January 3, 2013

**RE: Response to City Review Comments
Level I Site Plan Development Review Application
Motley Street Extension, Portland, Maine**

Sheet No.:  
**C3.1**

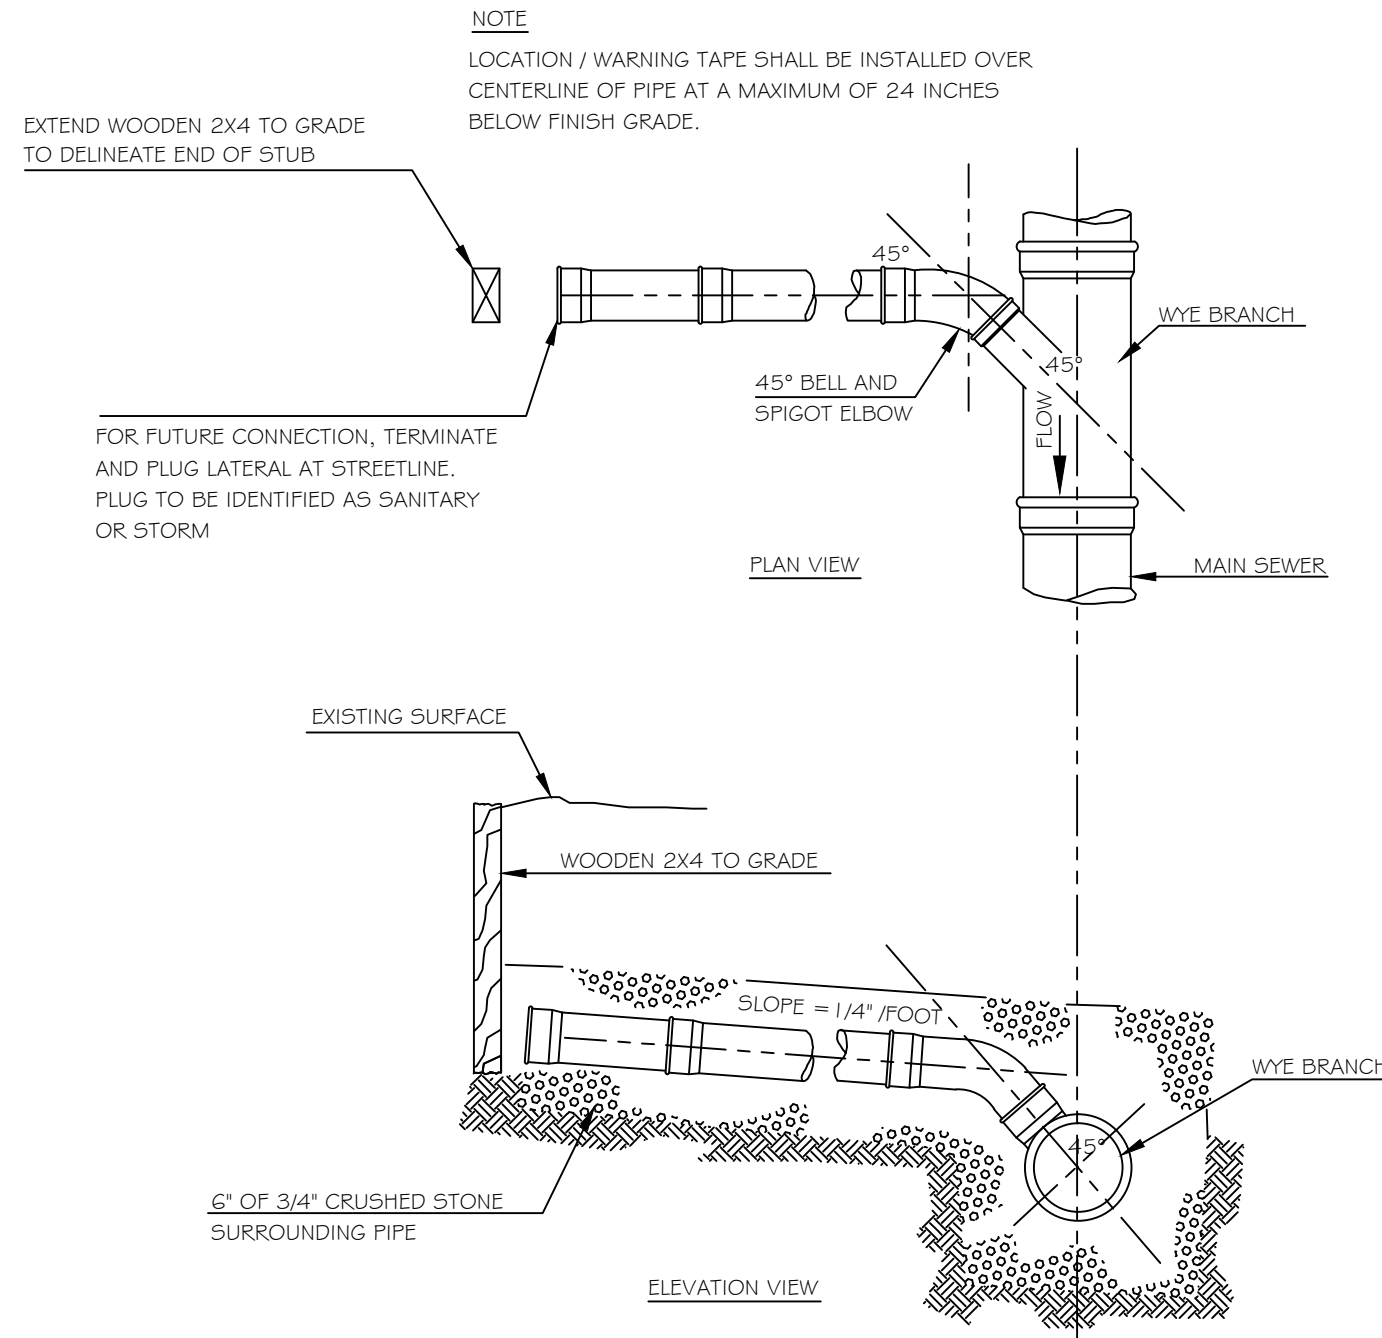
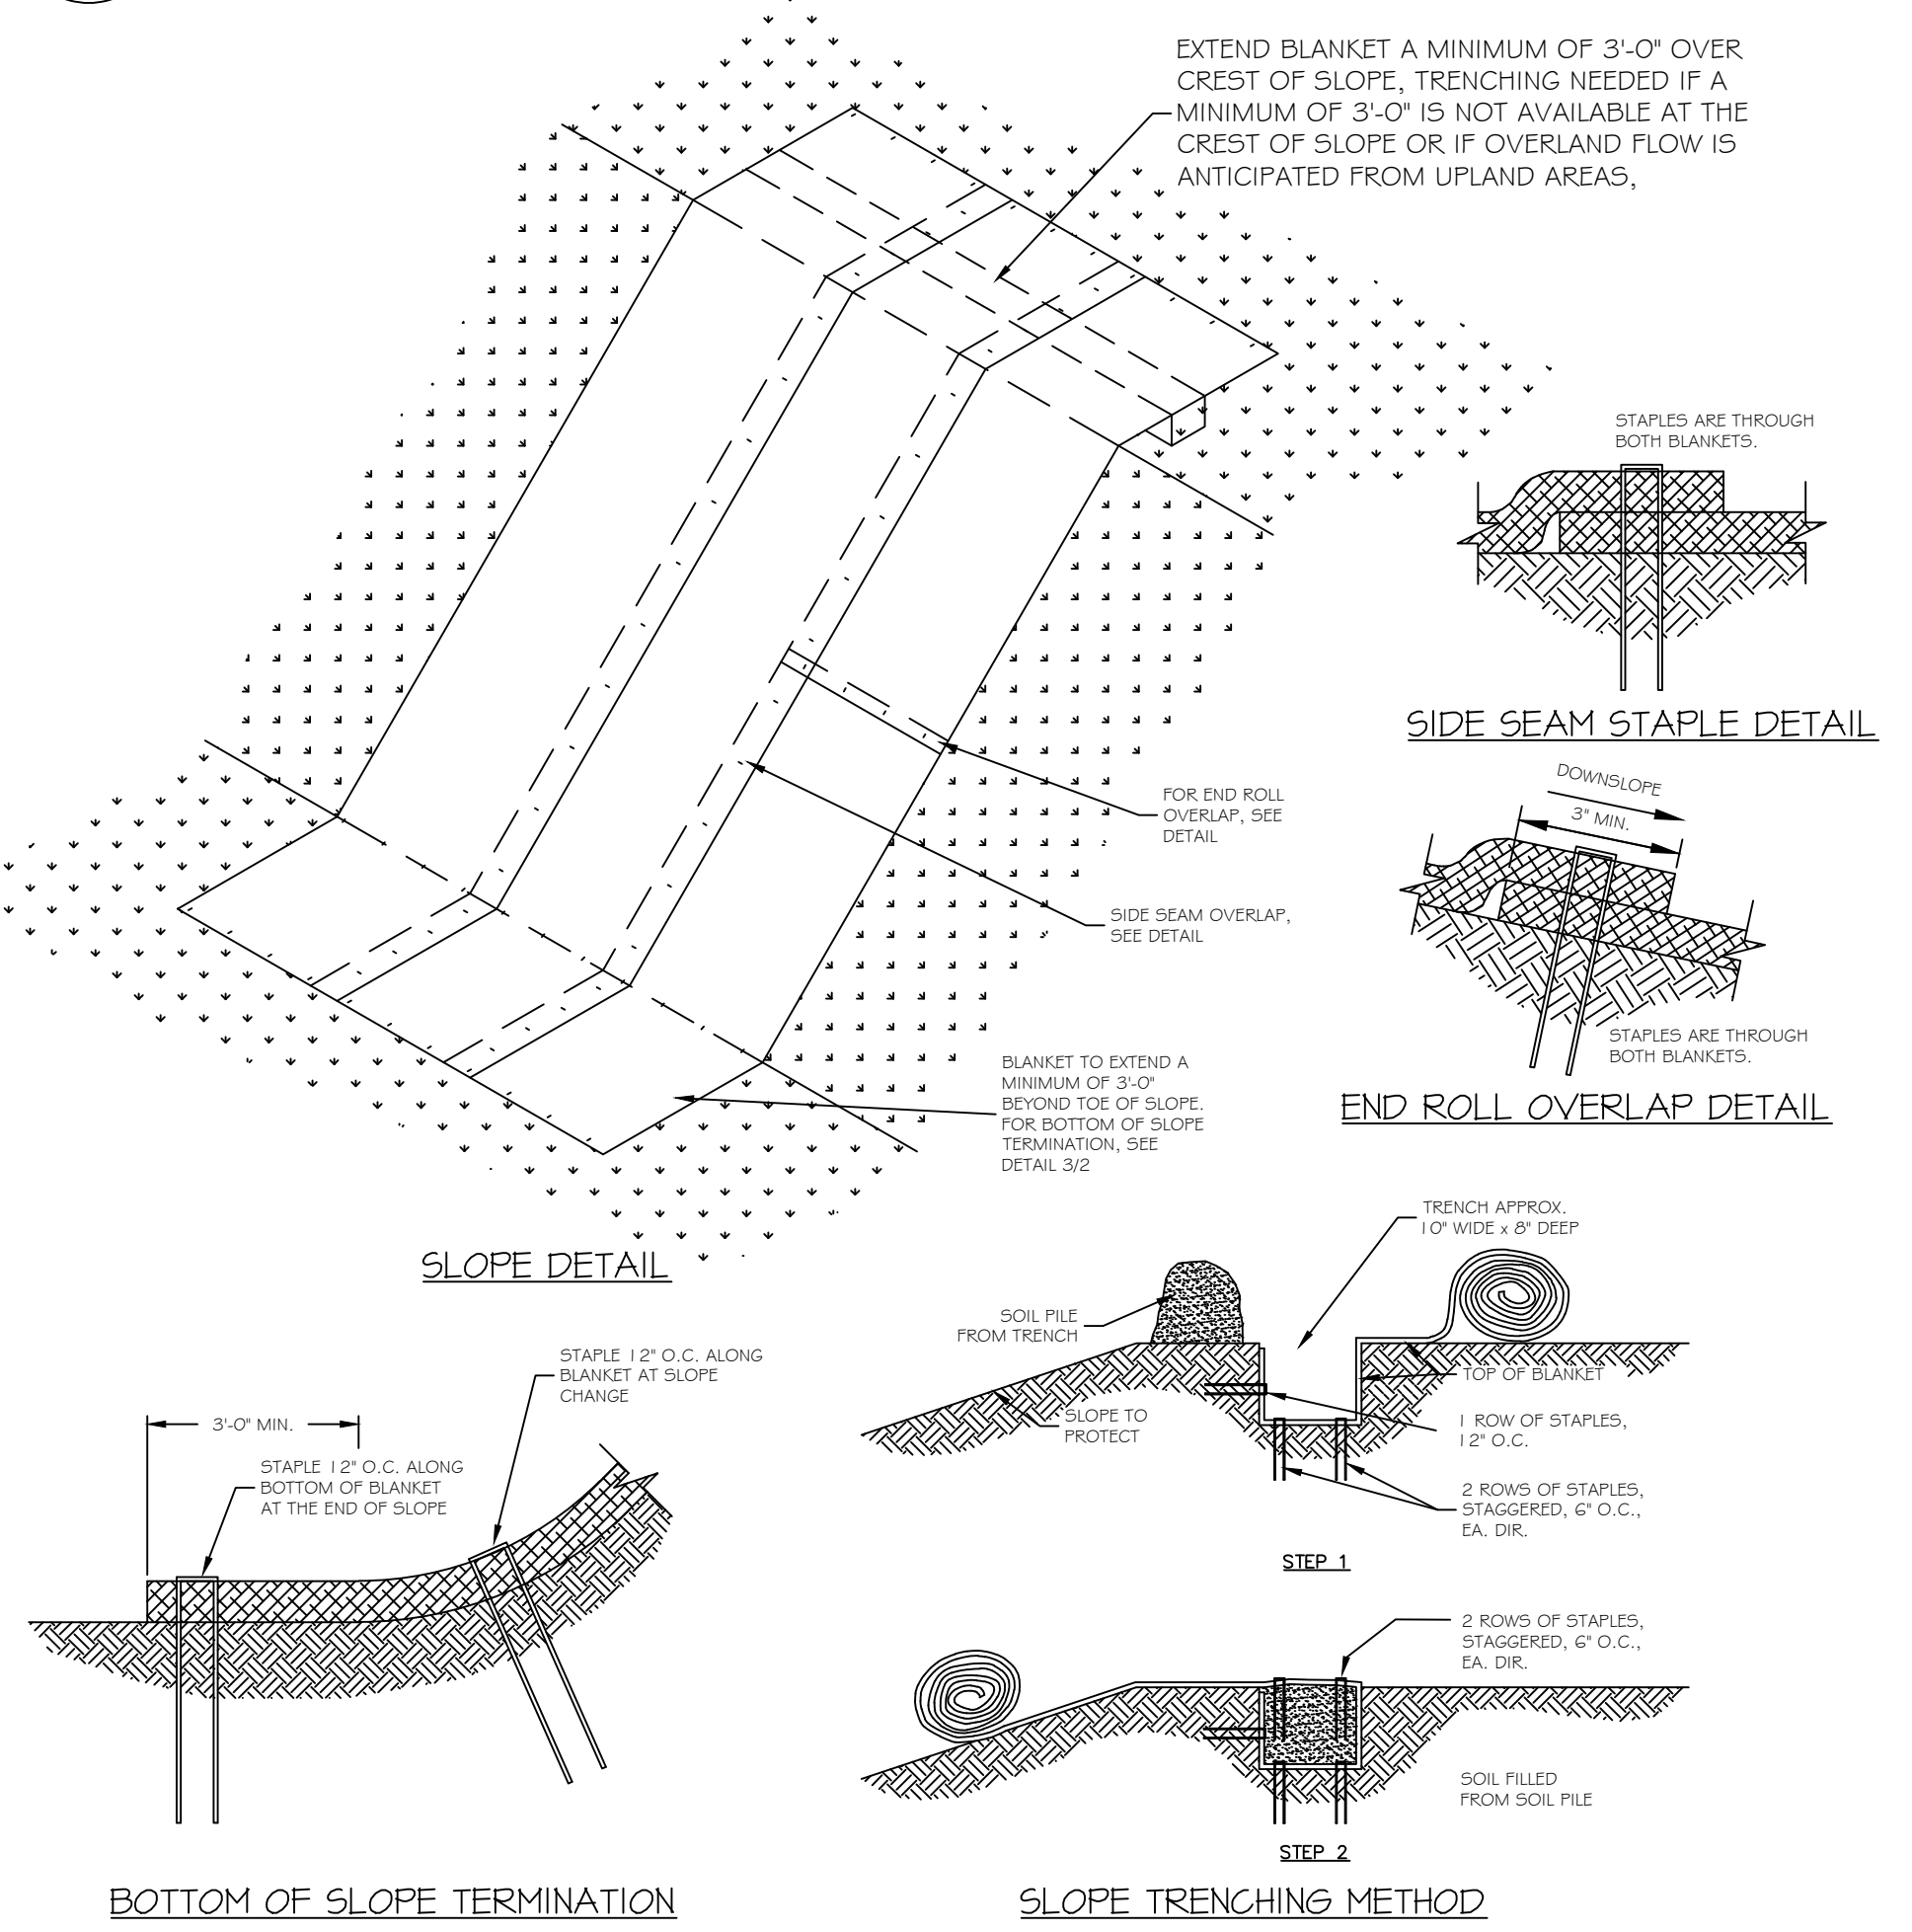
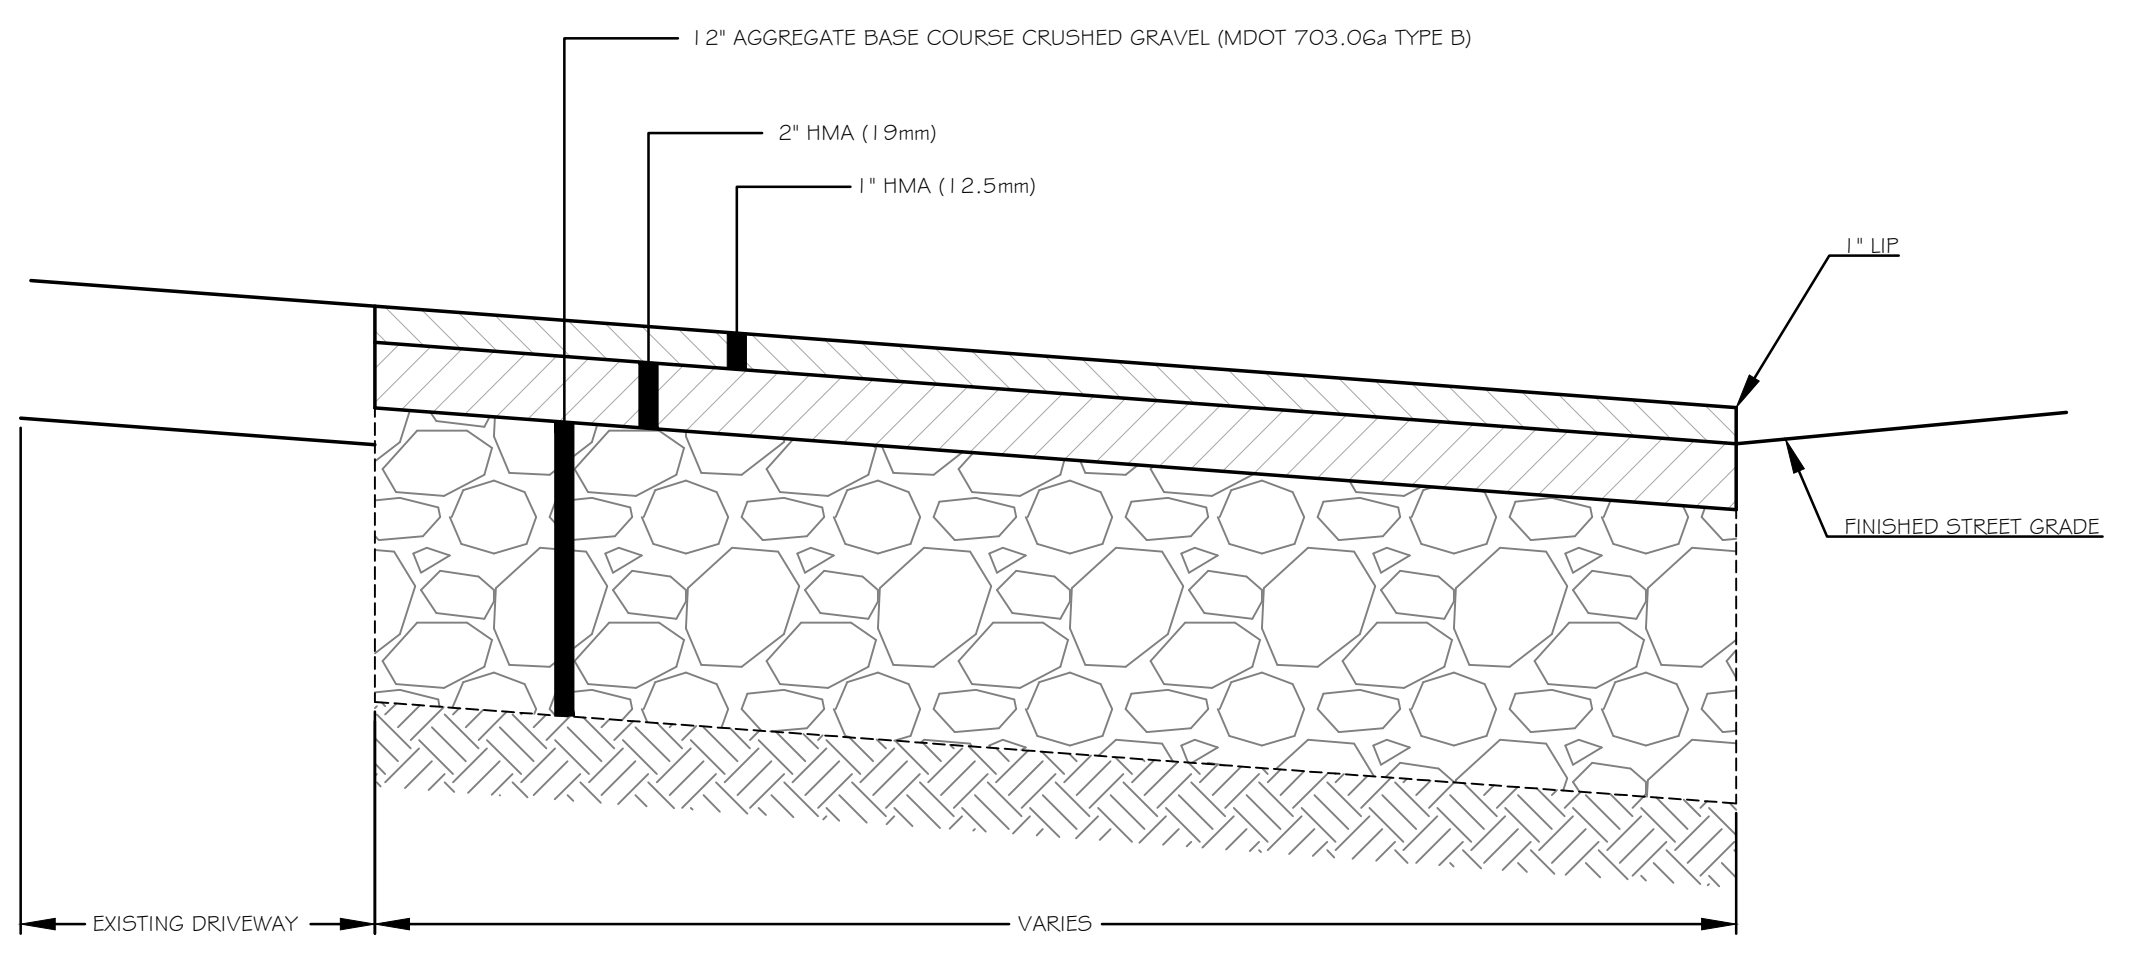
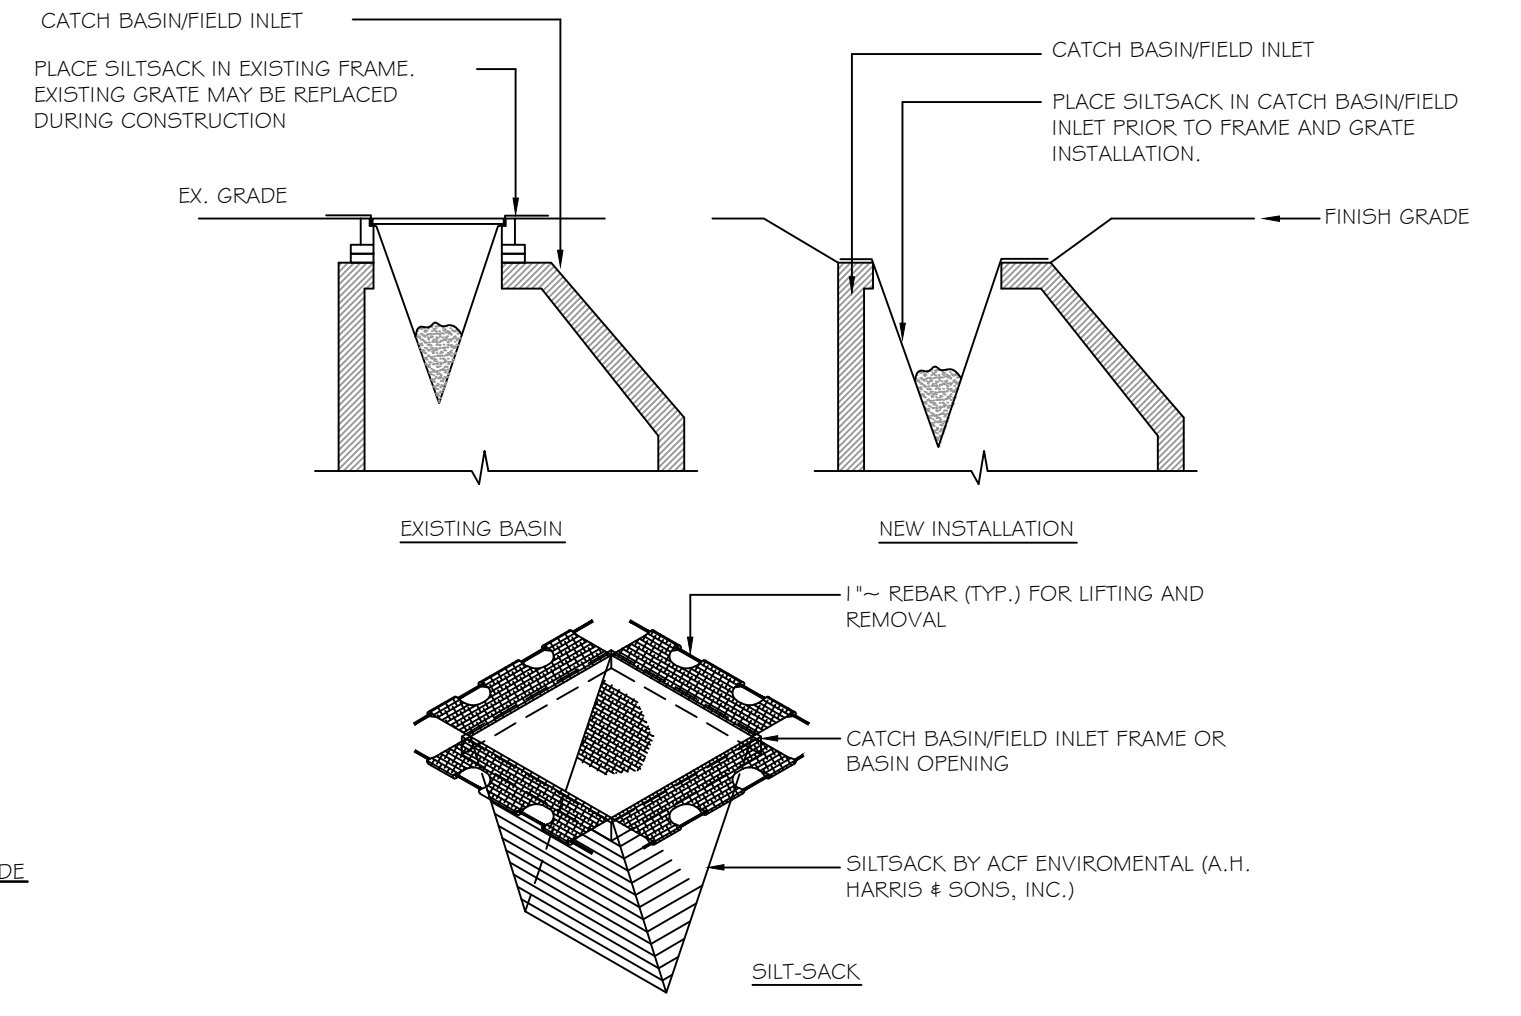
Catch basin inlet protection provisions have been added to the site plans. A symbol and leader note have been added to sheet C2.1 and the appropriate detail has been added to sheet C3.2 (detail #7).
